PLANNING BOARD REPORT PORTLAND, MAINE

Ten Unit Townhouses
70 Anderson Street
Level III Subdivision and Site Plan Review
2016-099
Redfern Properties, LLC, Applicant

Submitted to: Portland Planning Board: Public Hearing Date: September 27, 2016	Prepared by: Shukria Wiar Date: September 23, 2016
---	---

**SK-10**

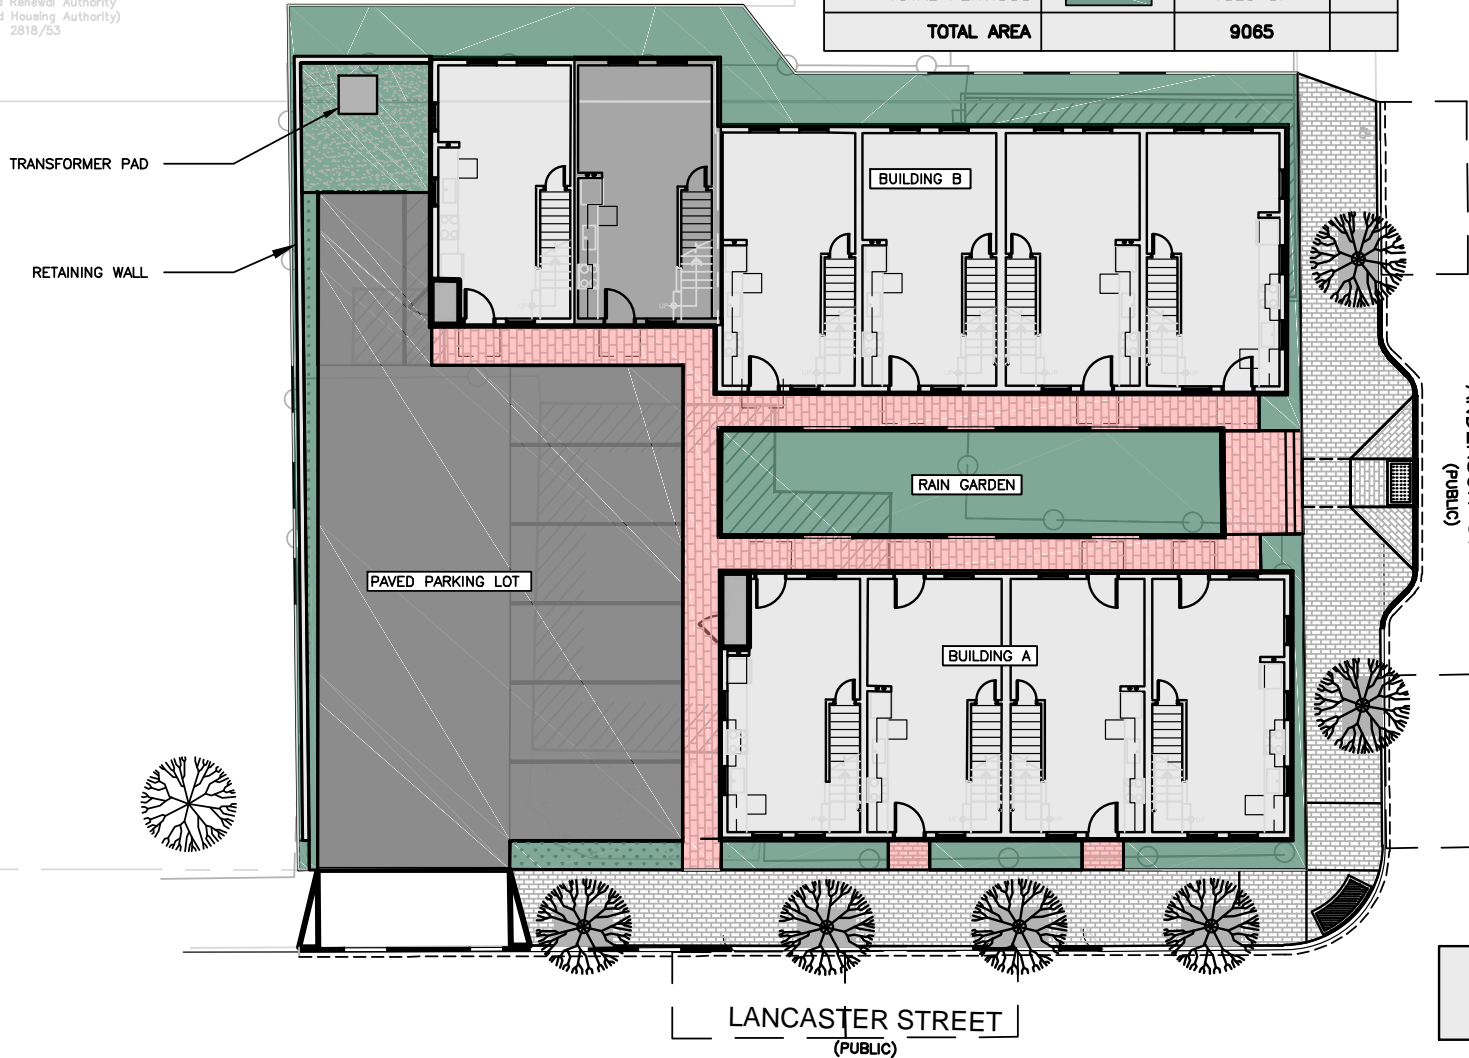
The proposed residential ten unit townhouses are a permitted use in the Residential R-6 which allows multi-family dwellings. Under the R-6 zone all of the dimensional requirements are being met, except for maximum lot coverage. The applicant will need to show documentation that they meet this standard. For off street parking, Division 20 requires one parking space per unit for residential uses on the peninsula, except in the R-6 zone, the first three spaces are exempt. A total of seven parking spaces are shown which meets the zoning requirement. Under external effects, section 14-167(b), the maximum noise requirement of 55 decibels at lot boundaries shall be maintained.

DRAWING NO.  
**PLAT**

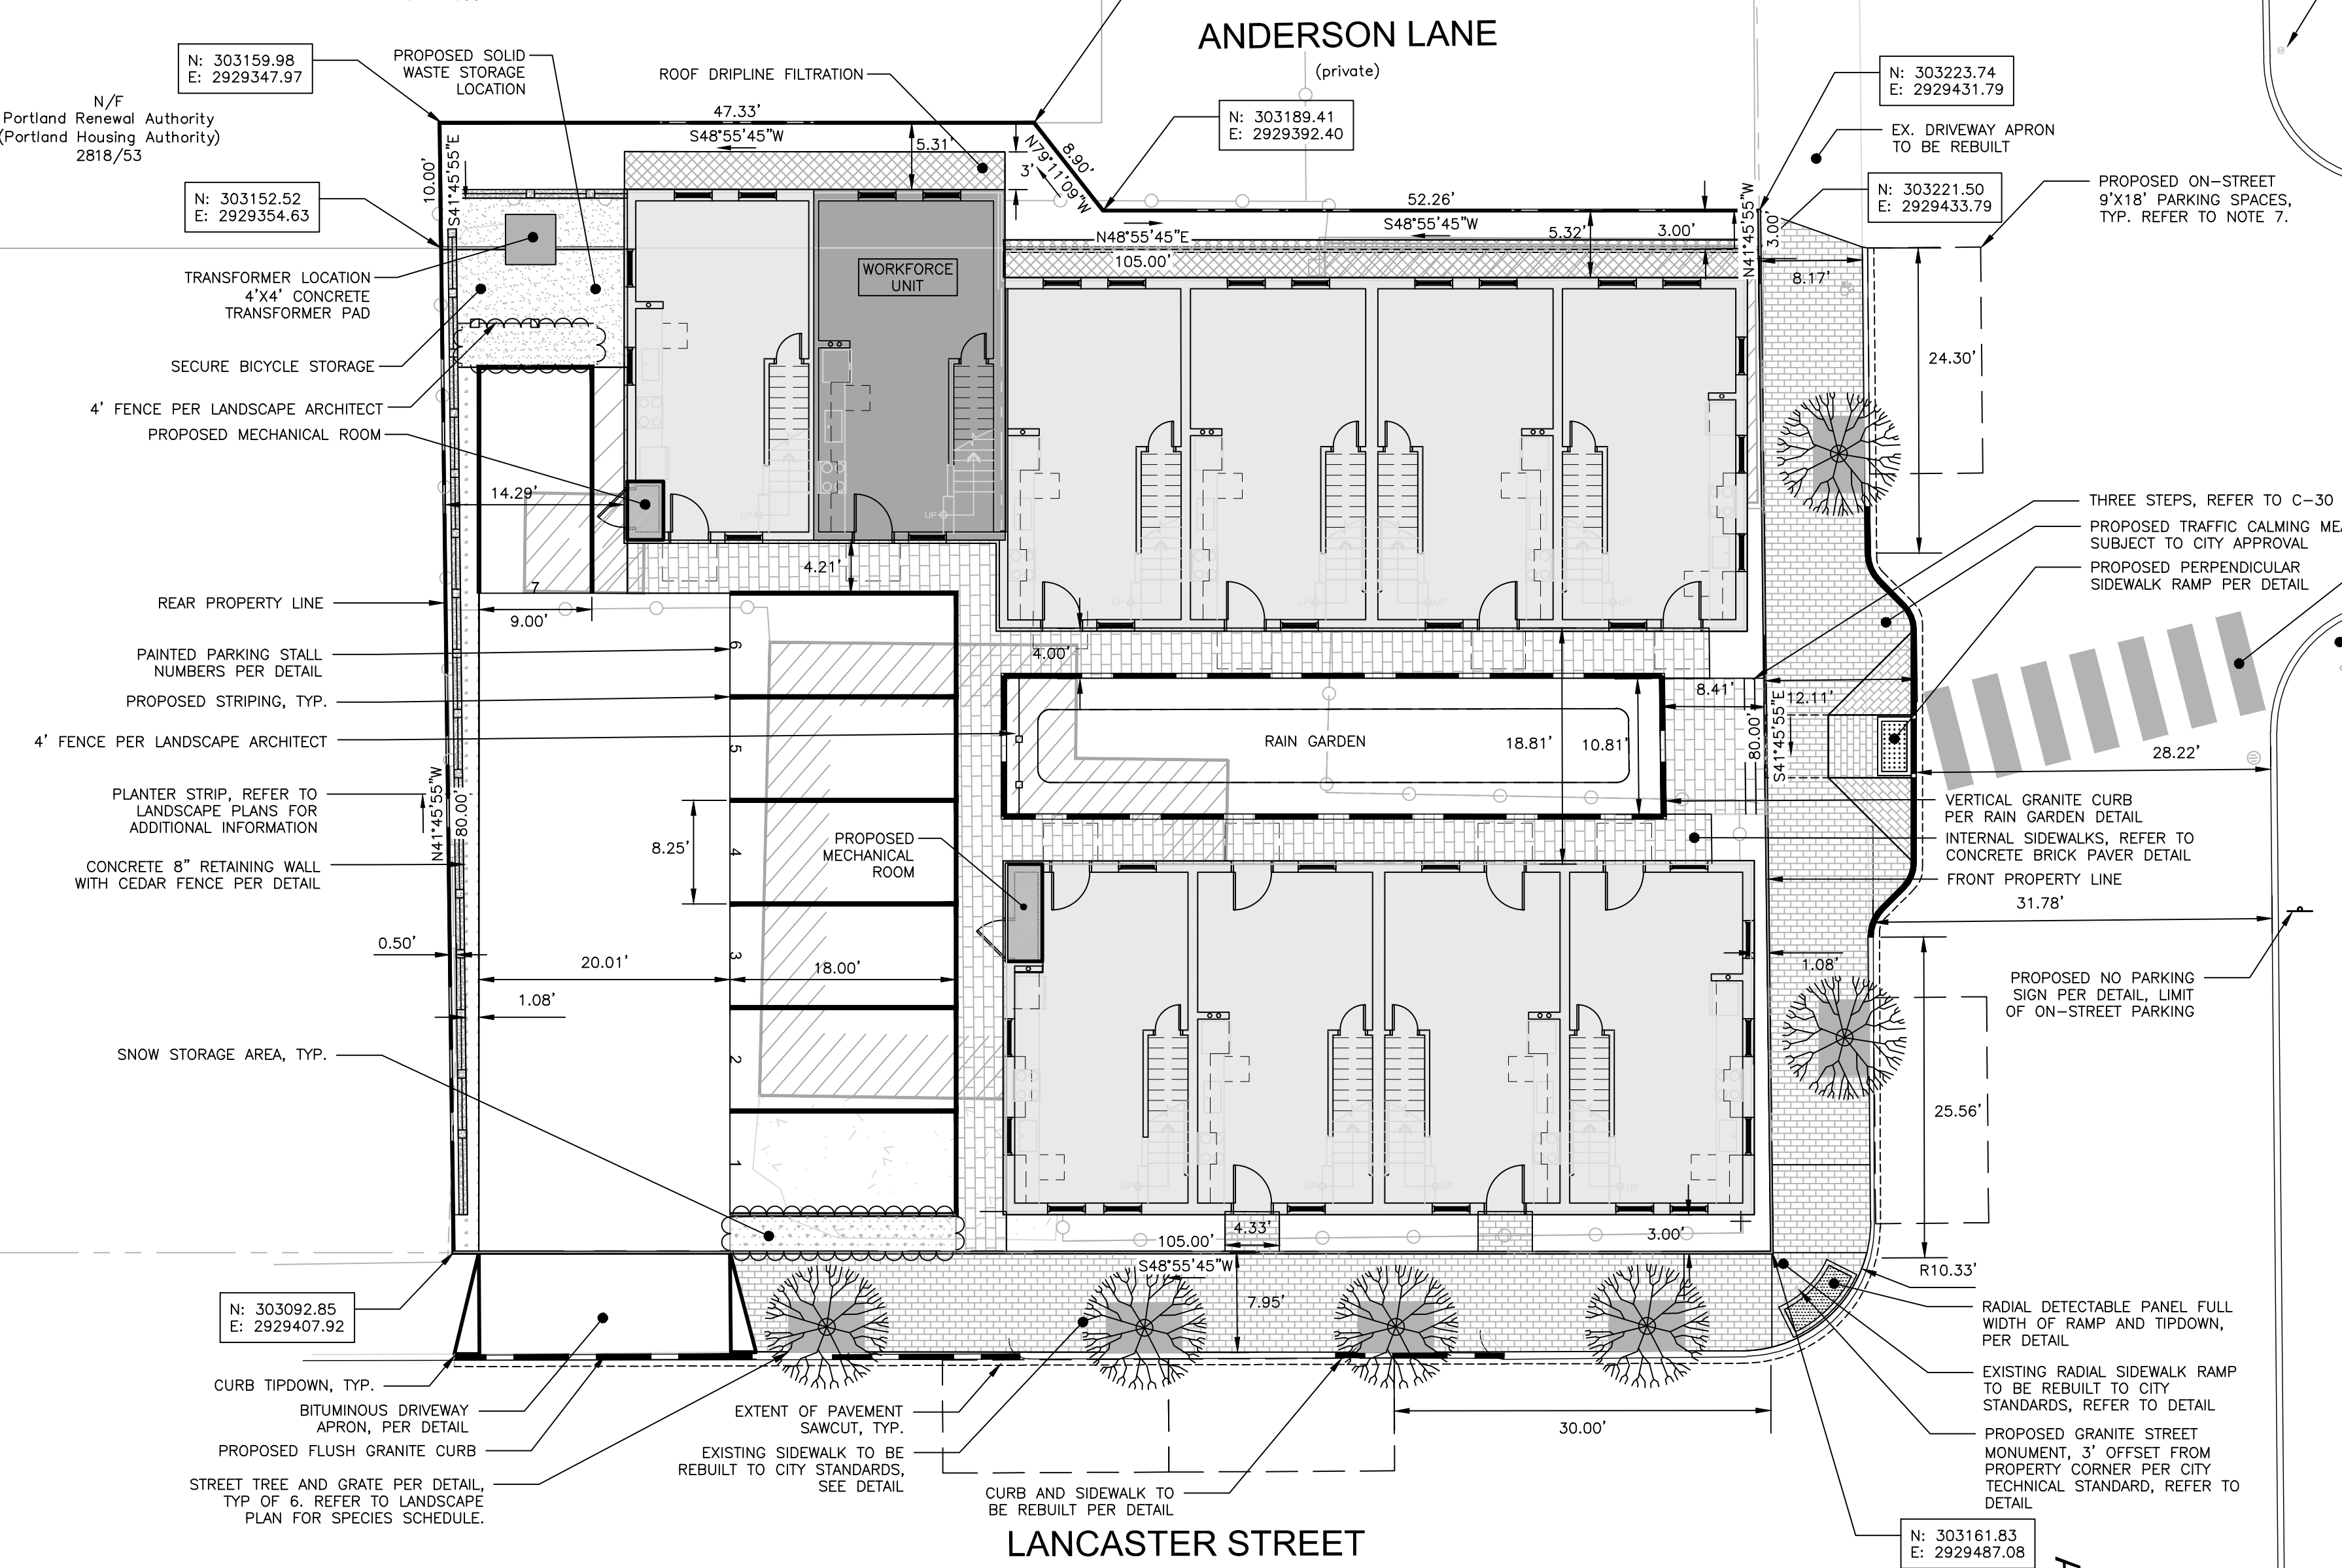
Bill Clark, City Surveyor, conducted a review of the plat and had concerns about a note on the proposed plat. He states that “the Survey Note #5 states that Fee Interest in Anderson Lane apparently lies with the heirs of Moses Gould as described in a deed recorded in Book 290, Page 310. The unrecorded release deed from Portland Housing Authority to Redfern Properties does not state that the Portland Housing Authority acquired title from the

heirs of Moses Gould". The applicant has submitted an unrecorded release deed from Portland Housing Authority (PHA); staff has requested the applicant to provide PHA source of title for Anderson Lane. Staff will work with the applicant to provide the appropriate documentation prior to the signing of the plat. Accordingly, review and approval of the final plat has been included as a condition of approval.

DRAWING NO. **C-10**

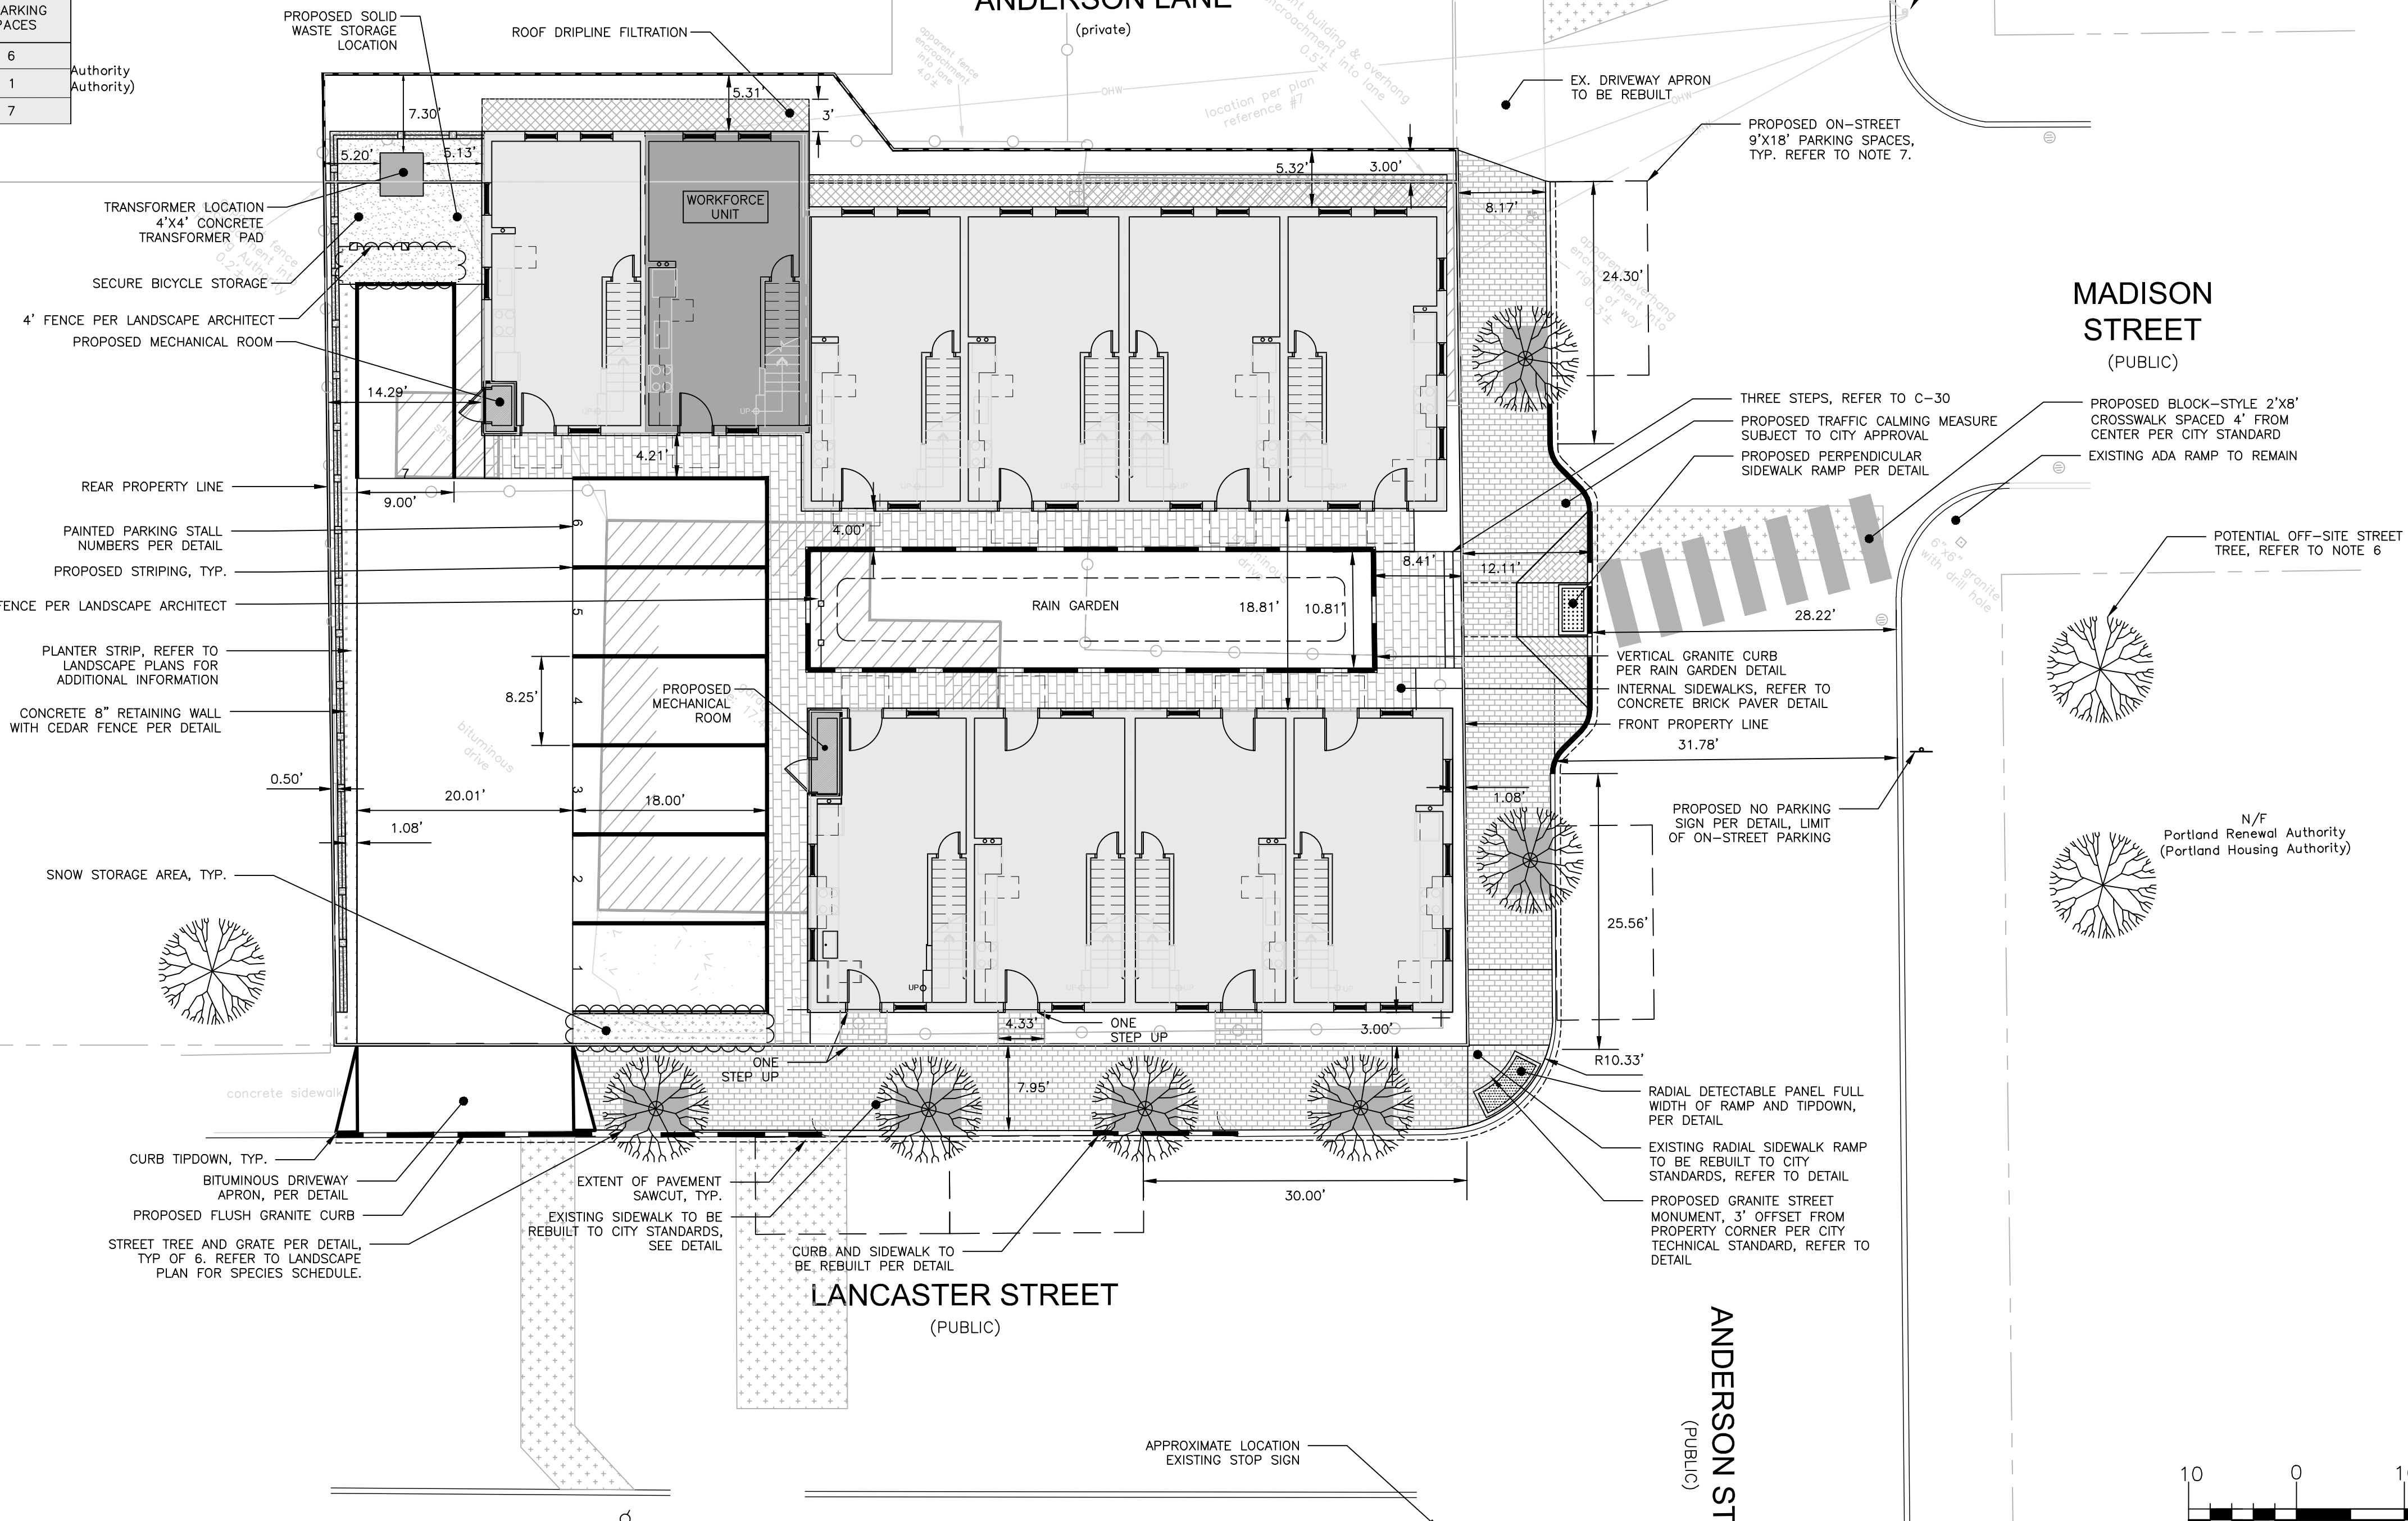
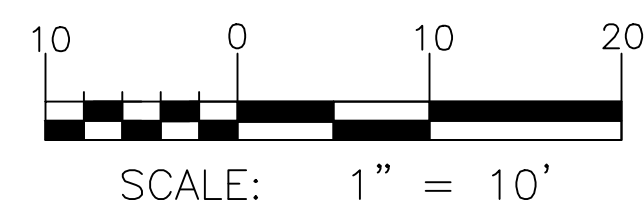
The applicant's plans also include the addition of a curb extension and a crosswalk at the intersection of Anderson Street and Madison Street. The City staff has reviewed the proposed plans and would recommend that the proposed crosswalk be perpendicular with ADA complaint curb ramps. In doing this, the pedestrian crossing may or may not consist of curb extensions on one or both sides of Anderson Street. City staff will work with the Applicant to get a final design for this area and have these changes be formalized on the plans. Mr. Errico states:

The details of the subject crosswalk needs further design development given site conditions on both the property frontage and on the corner of Madison Street. Bruce Hyman will be providing some general design criteria for the crosswalk. In general it is seeking a fully ADA compliant crossing that has a perpendicular alignment. The applicant shall be responsible for developing concept designs for the crosswalk inclusive of ramp configurations on both sides of the street. Upon receipt of the concept plans, City staff (Planning/DPW/Fire) will review and provide comments on a preferred design. The applicant will be responsible for construction of the ultimate design along their property frontage only.

The applicant is also proposing a sidewalk ramp at E. Lancaster and Anderson Street intersection. This ramp will have to be a fully ADA complaint. In regard to this ramp, Mr. Errico has stated *“Adjustment to the ramp design is suggested given that a crossing of Anderson Street is not formalized. The applicant shall provide a revised layout for review and approval. The applicant is only responsible for improvements on their corner of the intersection”*.

The surface parking lot will have a twenty foot (20’) parking aisle width that does not meet standard of twenty-four feet (24’); therefore the applicant has requested a waiver of this standard. An auto-turn analysis has been provided documenting adequate vehicle circulation and the information has been reviewed by the City’s traffic engineer, who states that *“the applicant has provided an Auto-turn analysis and I support a waiver from City standards given site characteristics”*.

The applicant is proposing a transformer and a solid waste storage at the rear of the property: according to the site plan, both the solid waste and transformer will be screened by a four foot fence.
